From: Sue Howell
Sent: 11 October 2017 14:11
To: 'Slingo, Bradley'; Michael Eastham
Cc: Kennett, Darren
Subject: RE: Swanbourne Park - AL/82/12 - LEAP/LAP Proposals

Thank you for submitting LAP and LEAP proposals dwg BSH17576 31 A

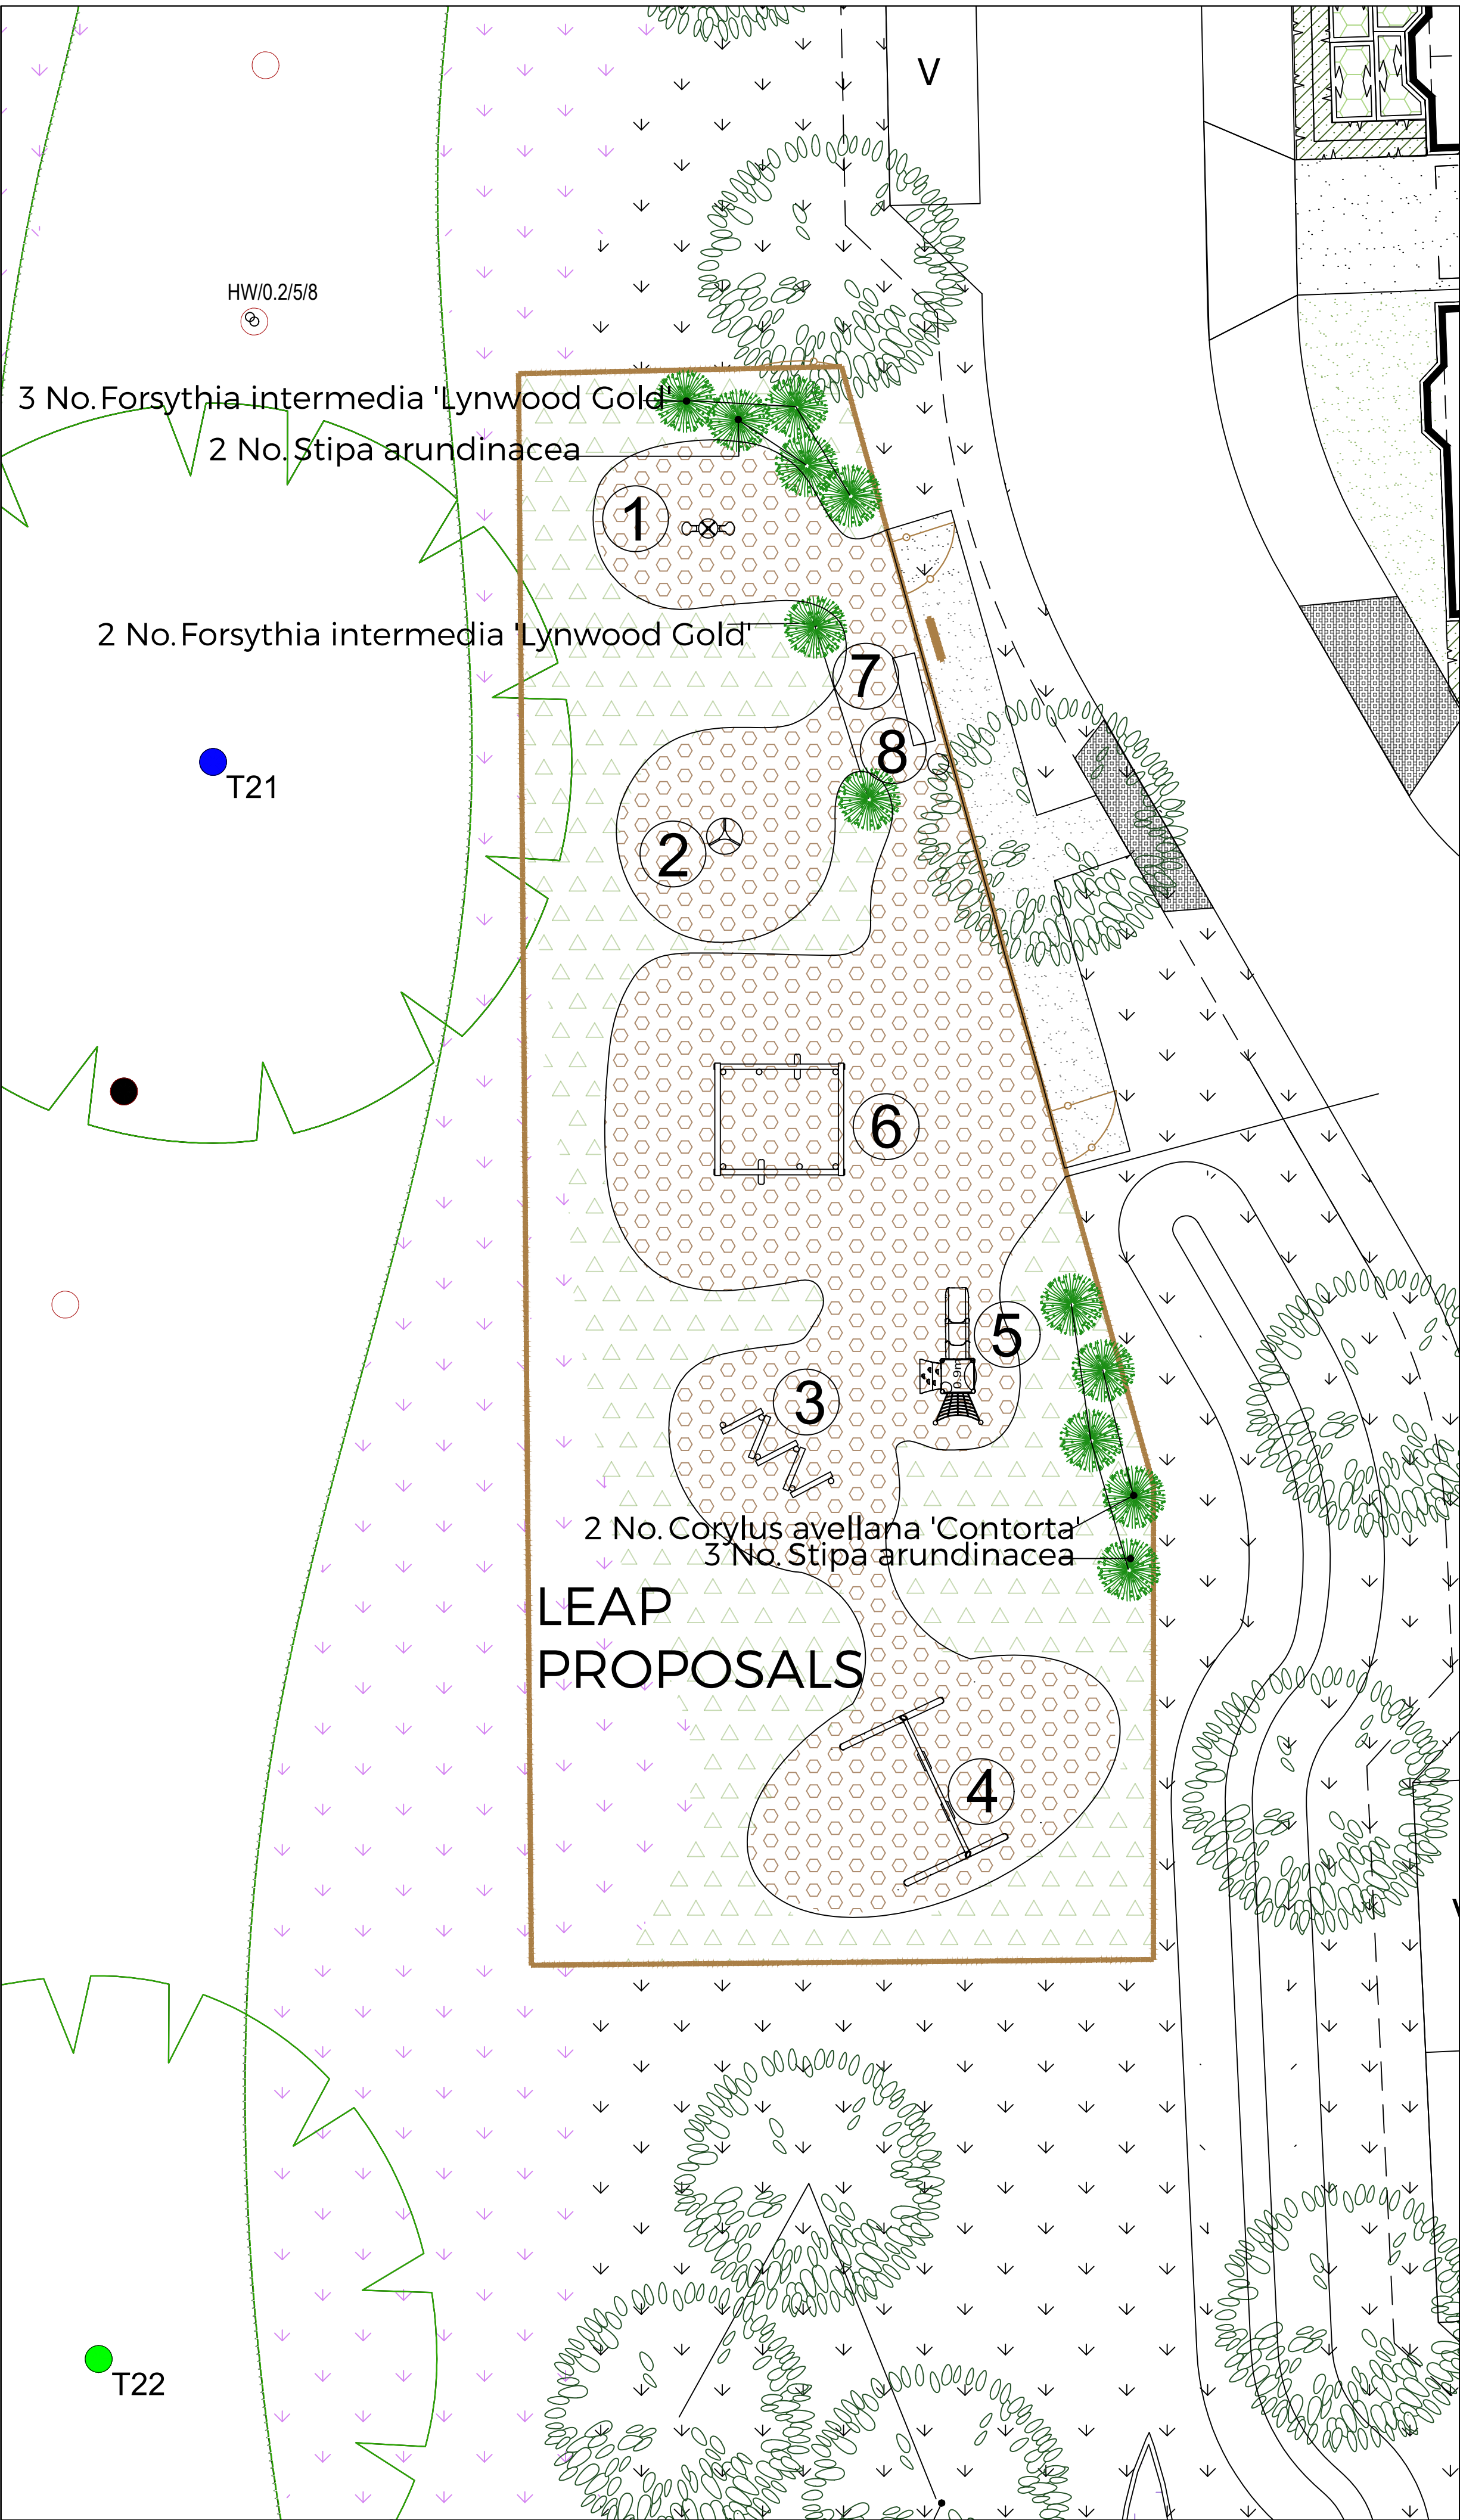
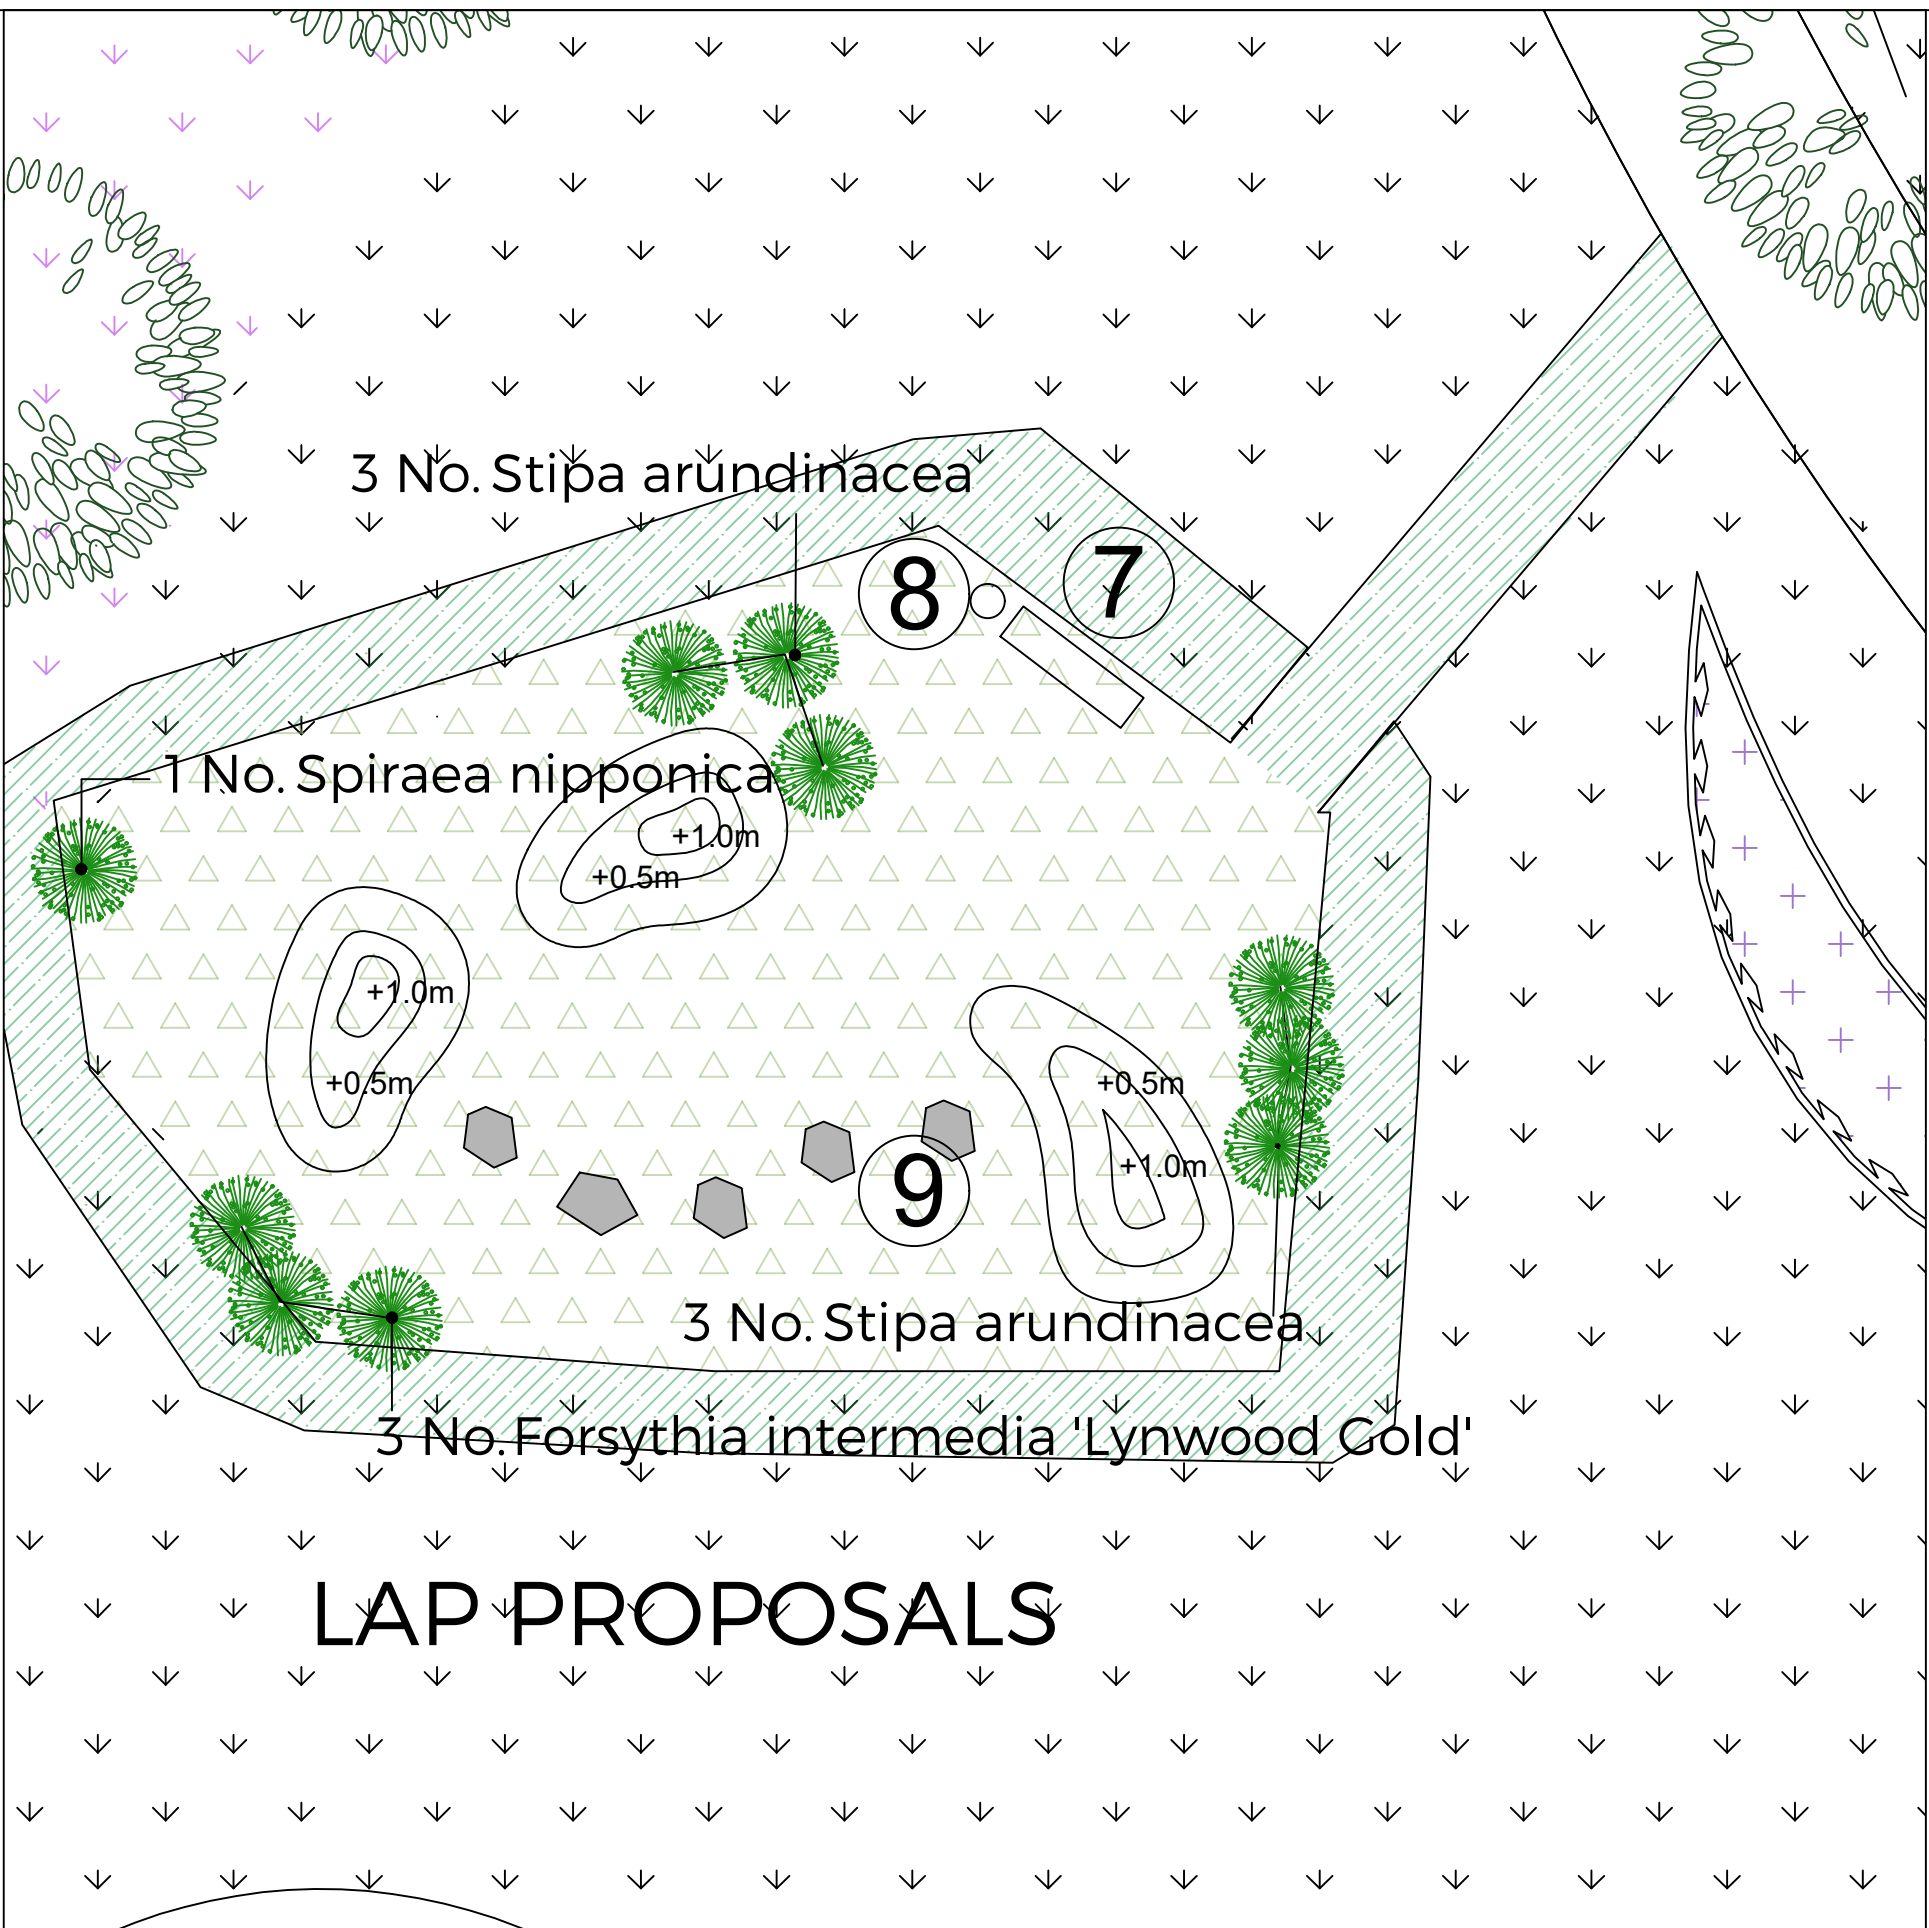
LEAP Needs to provide a minimum of six experiences and be designed and laid out specifically for children who are beginning to go out and play independently. This should provide stimulating and challenging play experiences. I do not believe that the offer being presented caters for this criteria, therefore please reassess

the offer here, amend and re-submit. Gates when incorporated into a fenced areas are better to be accessed via pathways to make these more user/wear friendly. Please detail fence type where indicated for fencing.

LAP This should be a small area of open space – Not fenced specifically designated and primarily laid out for very young children to play close to where they live. This we do not need to see equipped but to have some natural play experience ie mounds, boulders natural play. The provision of a seat in this area is still acceptable. Please remove formal fenced and tarmac detail, amend and resubmit.
